<b>Your Ref</b>	SSD-10416
<b>Our Ref</b>	NCA/2/2020
<b>Contact</b>	Paul Sartor
<b>Telephone</b>	9806 5740
<b>Email</b>	<a href="mailto:psartor@cityofparramatta.nsw.gov.au">psartor@cityofparramatta.nsw.gov.au</a>

**20 June 2022**

**COUNCIL SUBMISSION  
NOTICE OF EXHIBITION OF RESPONSE TO SUBMISSIONS REPORT FOR THE  
PARRAMATTA POWERHOUSE (30B PHILLIP ST, PARRAMATTA)**

4 PROPOSED ELEVATION W  
1 : 100

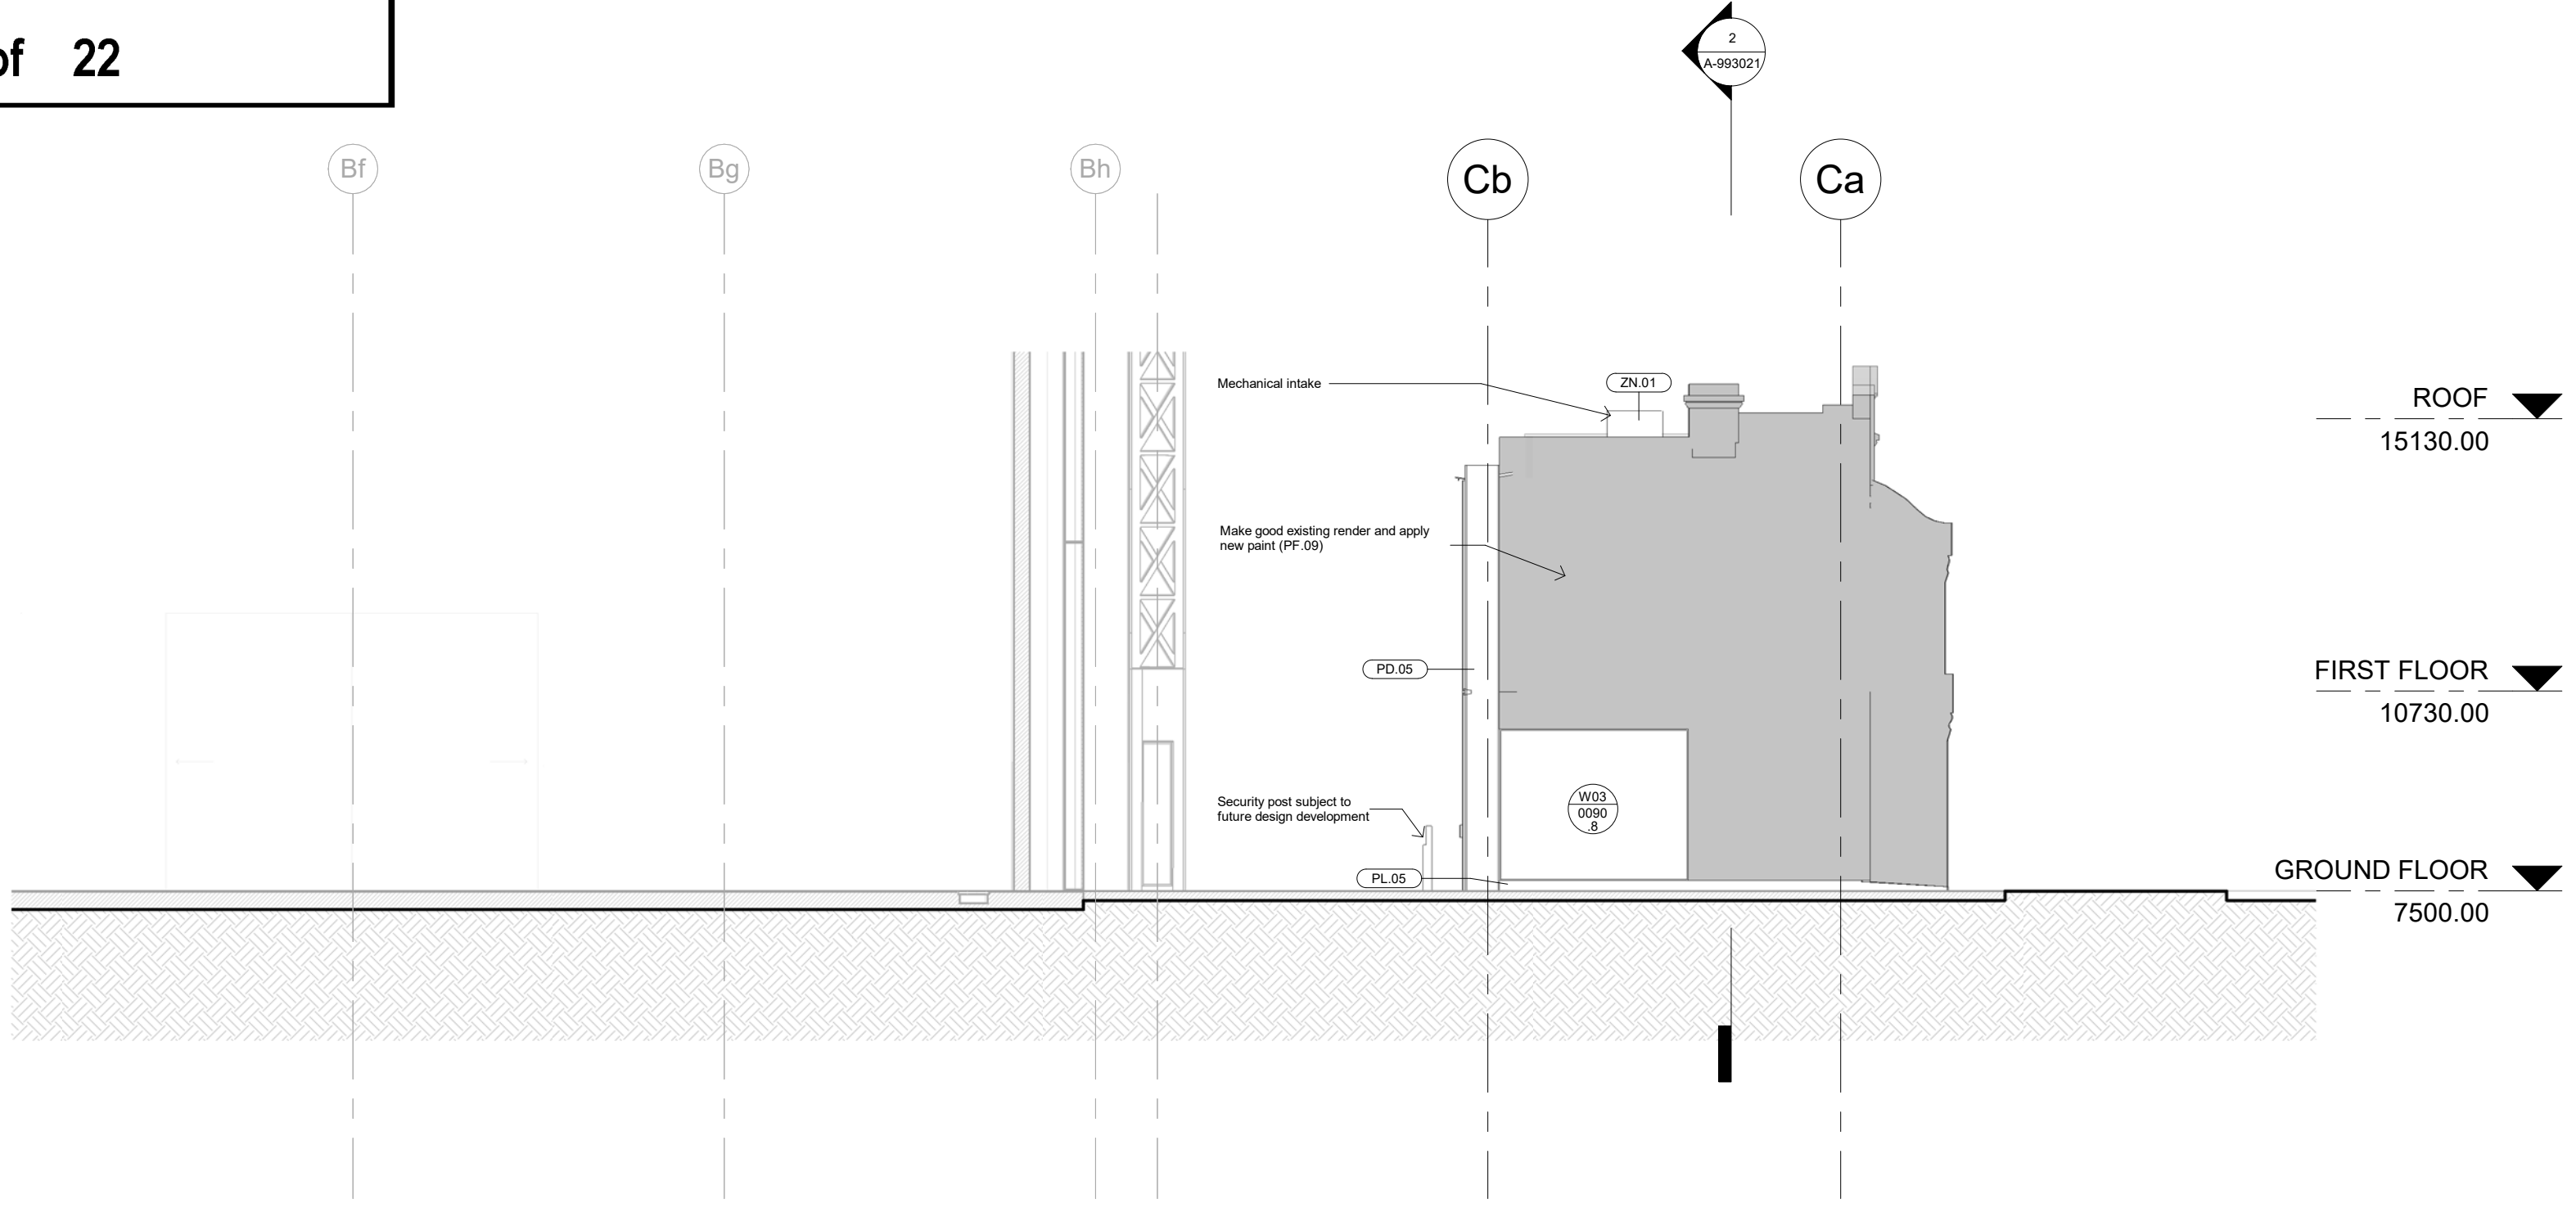
- The large and generous opening at the rear and the removal of the chimneys together with the missing interpretation and reinstatement of the Victorian street presentation (veranda and balconies) of this row would completely change the street frontage presentation by creating a confusing reading of the existing proportions.
- The applicant is concerned that Council has requested changes to the doors and windows that would appear as an imitation. This is not the case, Council requests a design inspired by the Victorian proportions that would allow an appropriate interpretation of the original façade prior to the unsympathetic 1970s changes. The new elements requested are not supposed to appear as an imitation.

- The veranda reinstatement would make a significant contribution to the street view and overall heritage preservation. St George Terraces are a rare example of its typology of terraces within the Parramatta LGA and Parramatta CBD and should be restored to its maximum potential.
- The paving to the front of the terraces should also be differentiated from the rest of the development floor treatment. This should be seen not as a limitation but as an opportunity for heritage interpretation.
- Respectful preservation and appropriate interpretation of the original façade features are required to achieve an exemplary sample of heritage adaptive reuse of the existing and remaining of the Victorian heritage façade.
